## Department of Primary Industries

### **Glendell Mine (DA 80/952 MOD 3) Comment on the Environmental Assessment**

The Department has reviewed the Environmental Assessment and provides the following comments.

Figure 2: Proposed transmission line alignment

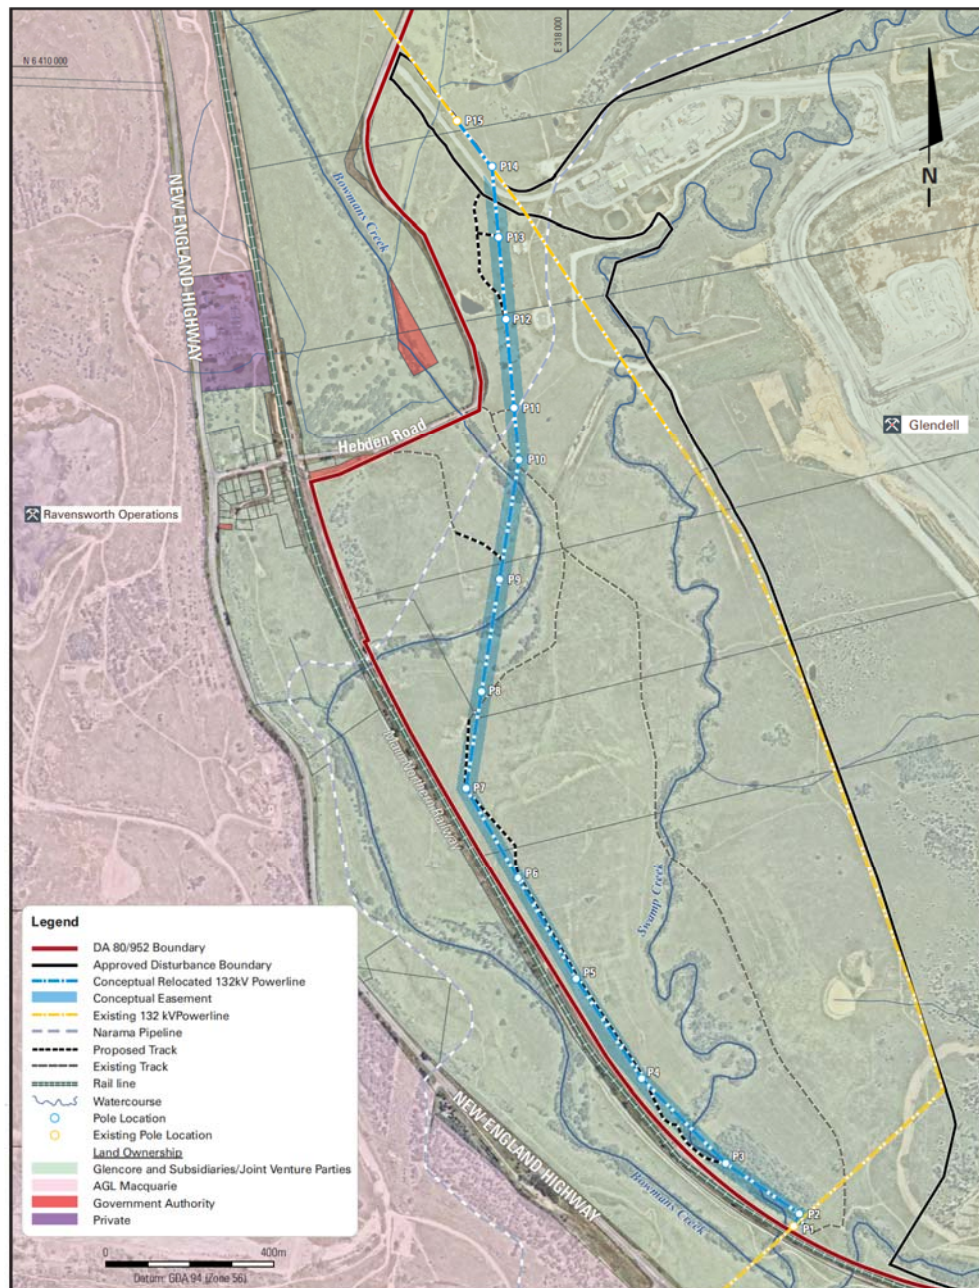
The modification includes the relocation of a powerline within the DA 80/952 project boundary but outside the disturbance boundary with Figure 4 depicting the conceptual powerline easement.

The proposed powerline relocation includes works within waterfront land and the traversing of watercourses. As noted in the Environmental Assessment, Part 2 of Schedule 5 of the *Water Management (General) Regulation 2011* provides an exemption from the requirement to hold a controlled activity approval for activities carried out in accordance with a right in force under the *Mining Act 1992*. However DPI recommends that DPI Water Guidelines for Controlled Activities are considered for any activities on waterfront land.

DPI understands some vegetation clearing is required in accordance with Ausgrid Vegetation Protocols. For disturbance on waterfront land, areas of temporary clearing should be restored and areas of permanent clearing should be offset via appropriate revegetation works, consistent with the DPI Water Guidelines.

DPI also notes analysis undertaken in relation to the preferred route described in section 4.5. It is demonstrated in Table 3 that DPI Water recommended that the EA include robust justification for the selected alignment and alternatives considered. It is noted that the alternative routes are not described in detail in the EA, nor is the feasibility assessment of each individual alternative included in the EA. It is recommended that the proponent provide a more robust justification for the selection of the preferred route.
